From: [REDACTED]
Sent: 07 March 2018 12:23
To: Amber Willard
Subject: FG/115/17

Ms Willard: I would like to make a further point of objection to planning application FG/115 in its present form. In previous versions of the plan there was landscaping to the development which to some extent softened its impact on the neighbours. Now there appears to be none, and the tracked path for large vehicles shows them coming to within a metre of one of the houses. This is surely contrary to Policy GEN 7 (ii), which says that **Development will be permitted, provided it:**

DWG No. 628-04 rev. E

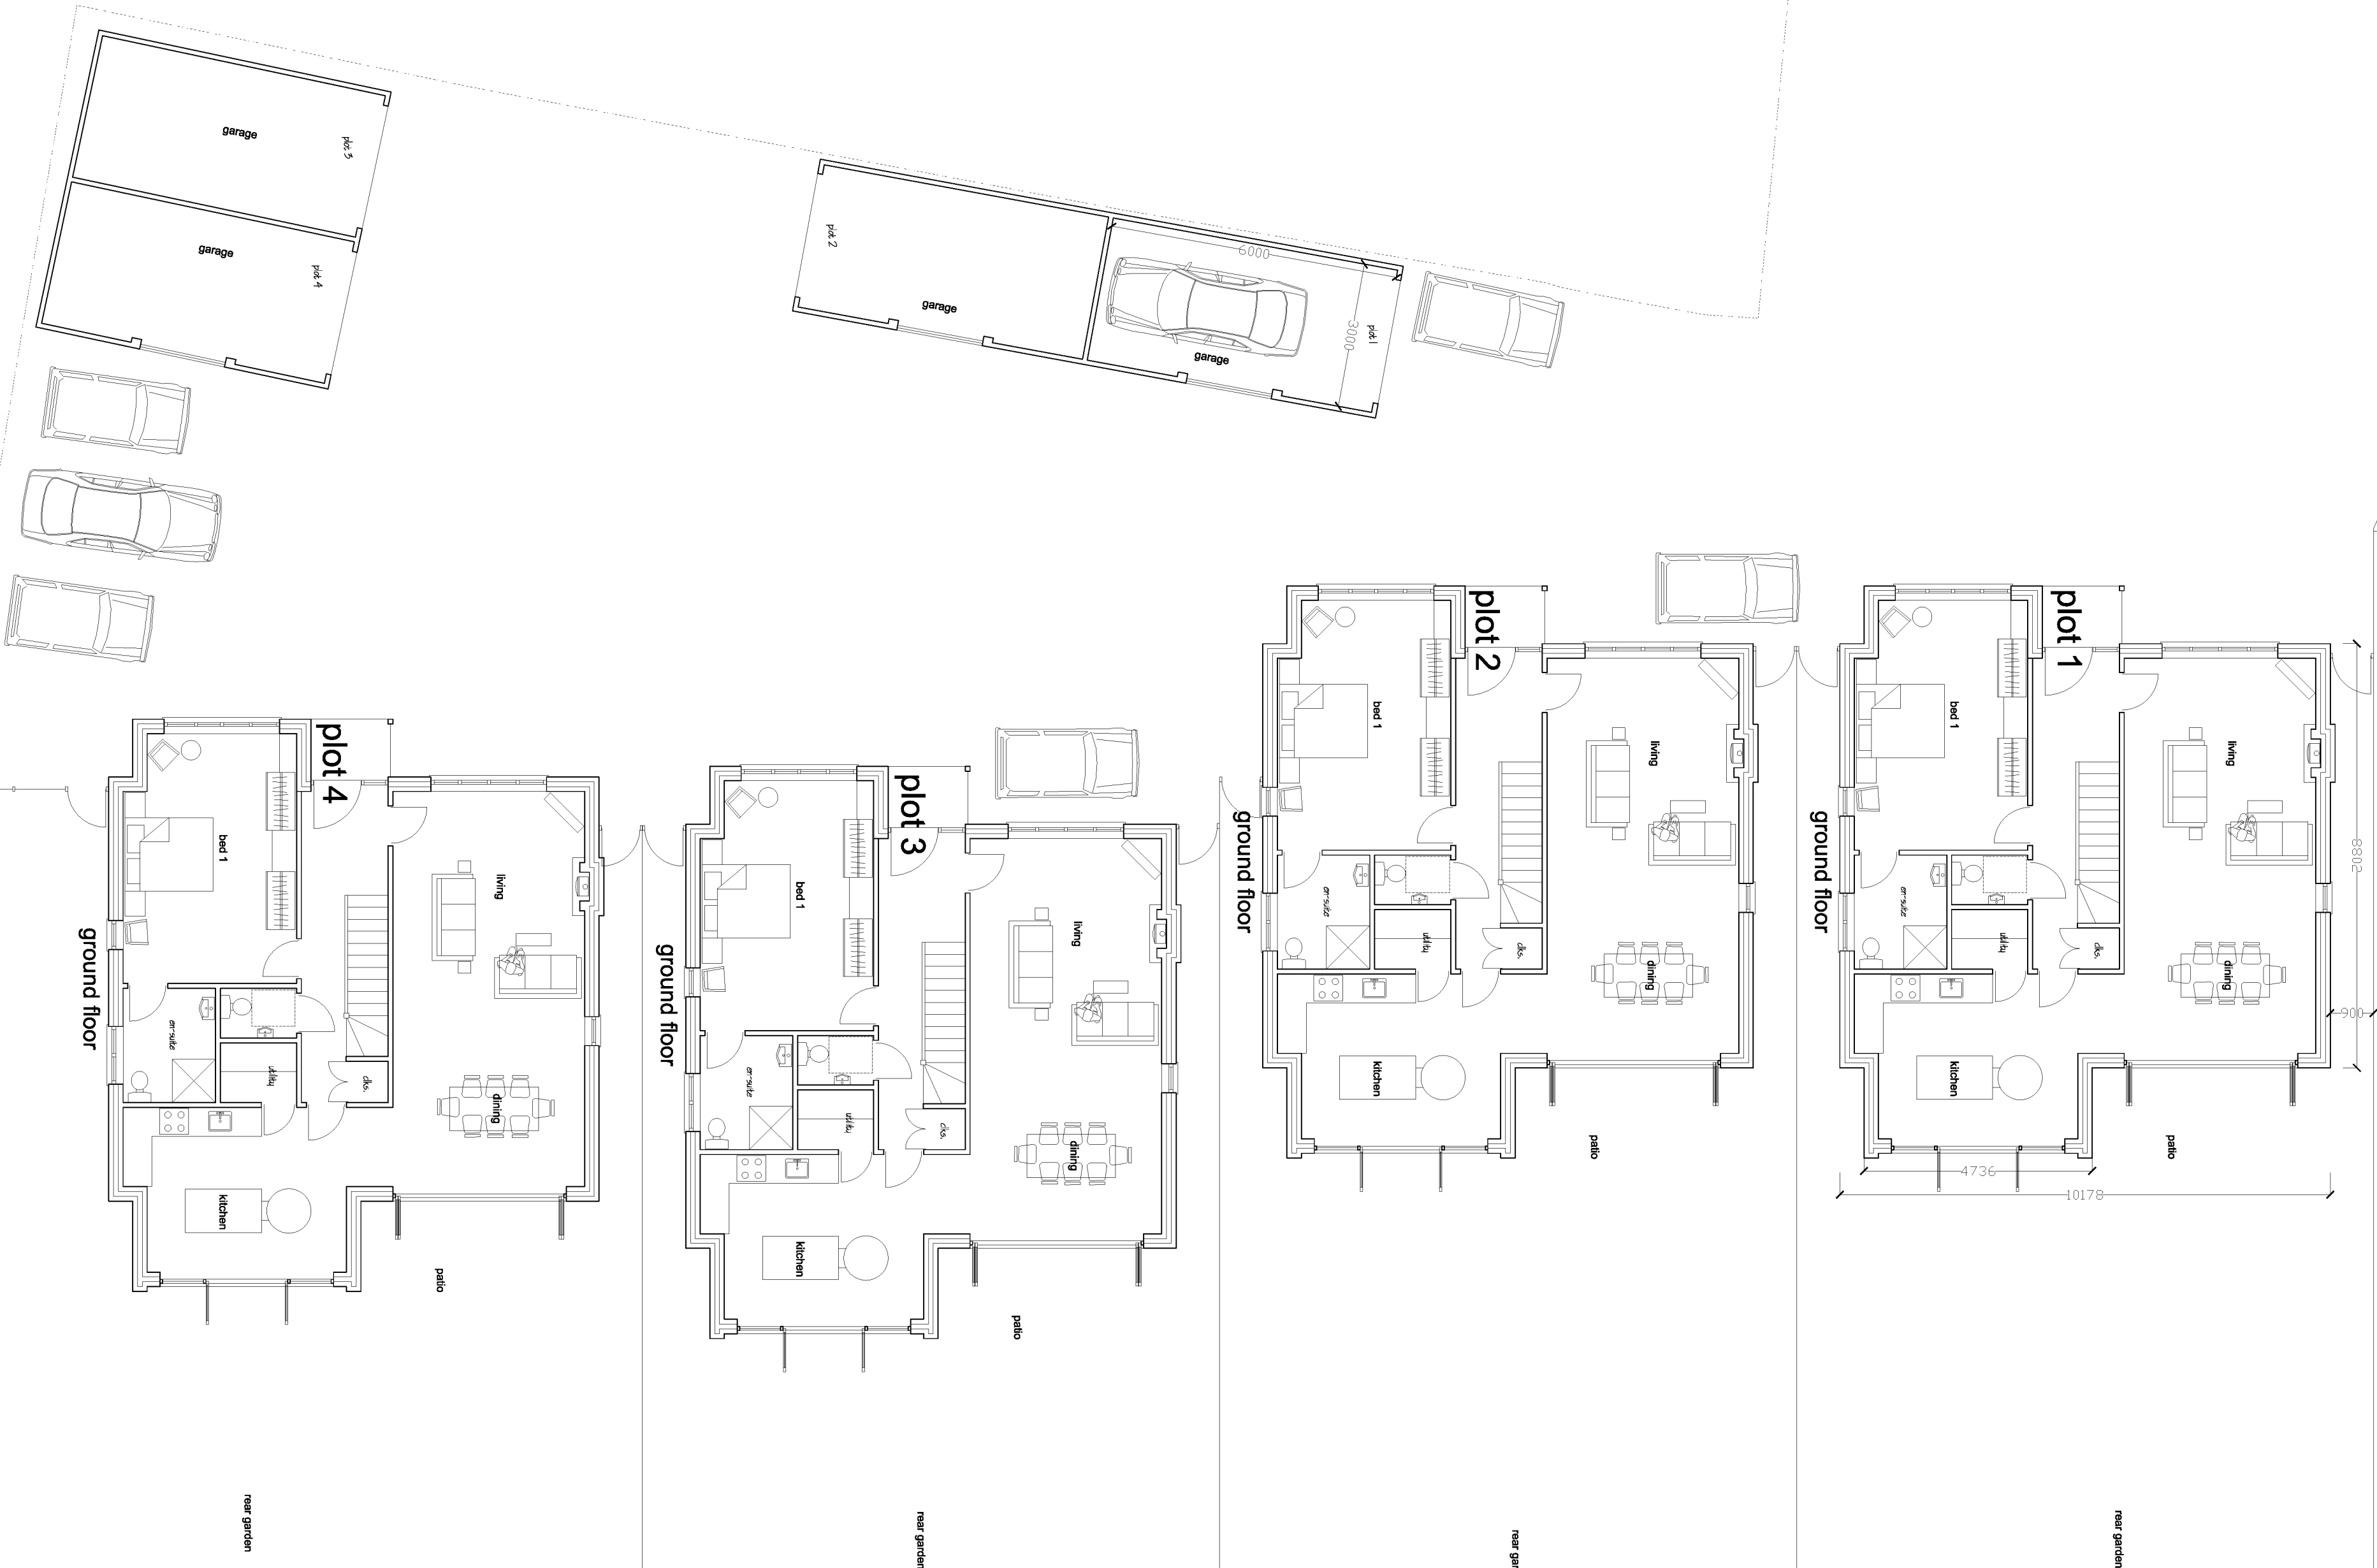
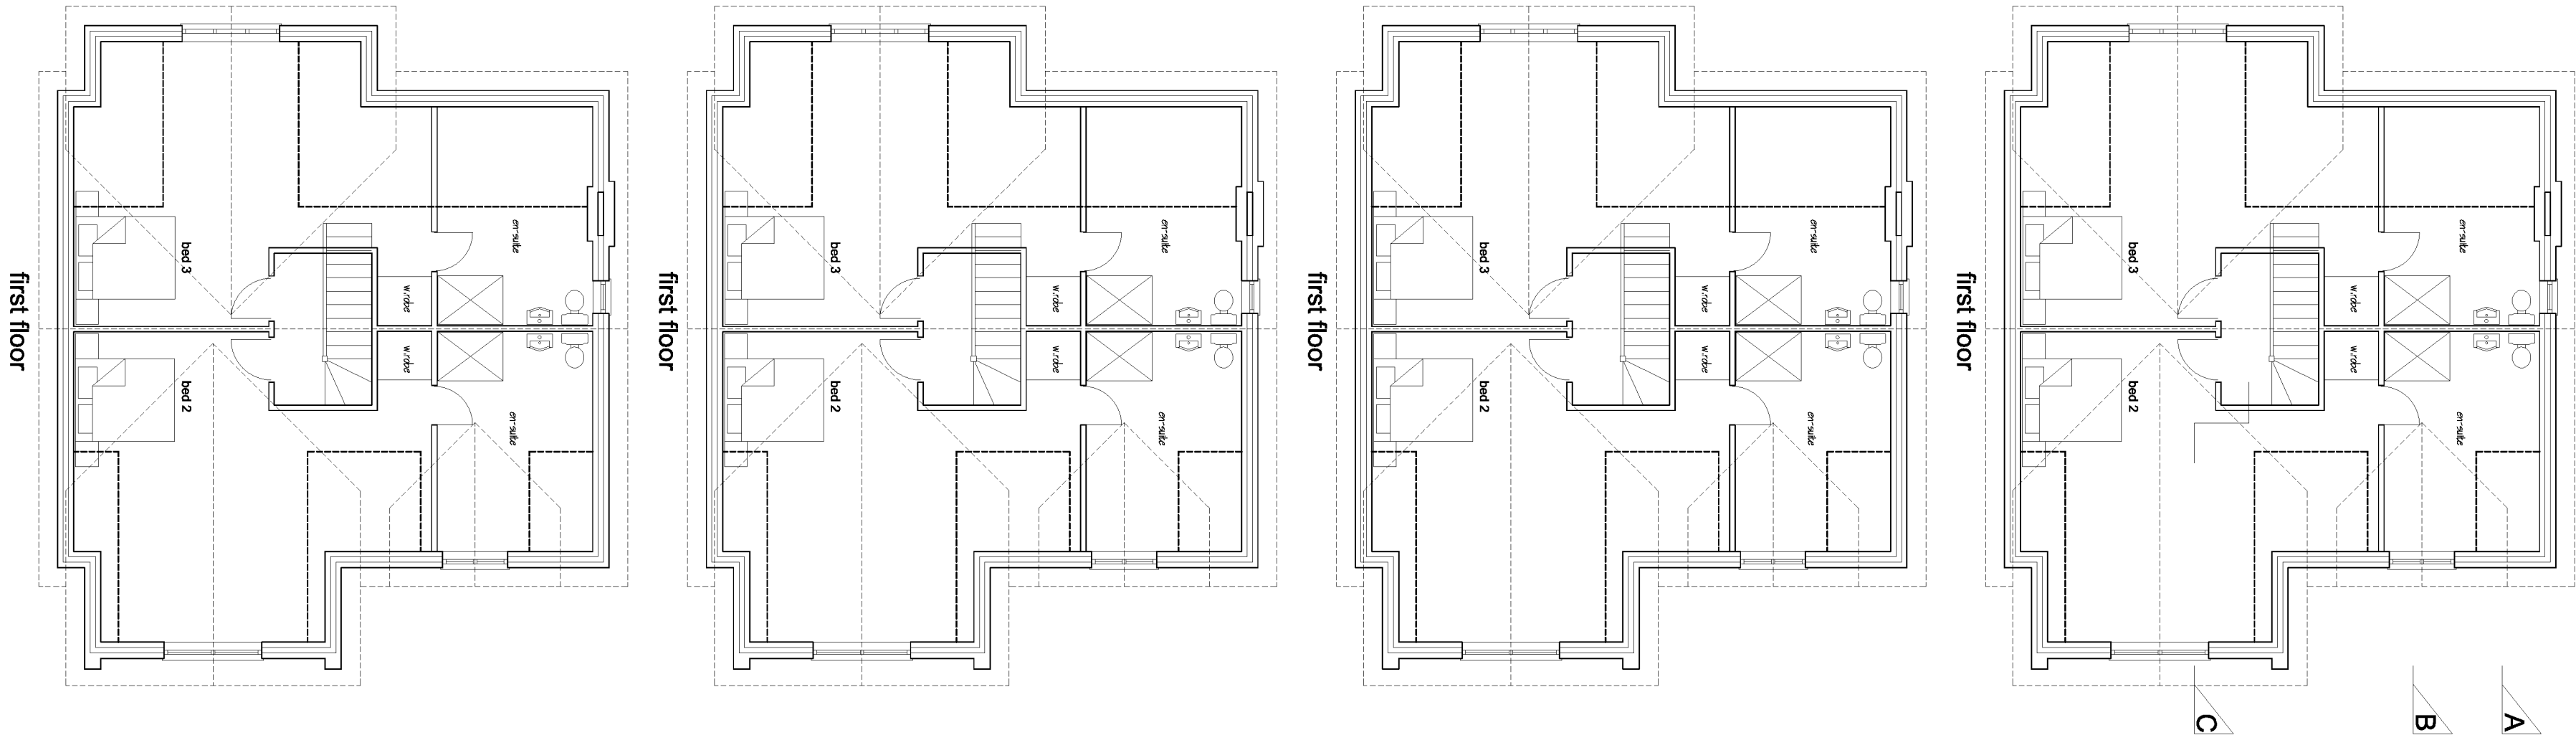
It is clear that this development does not demonstrate any of these requirements, and that the application should therefore be refused.
– Ed Miller (Secretary, Ferring Conservation Group)
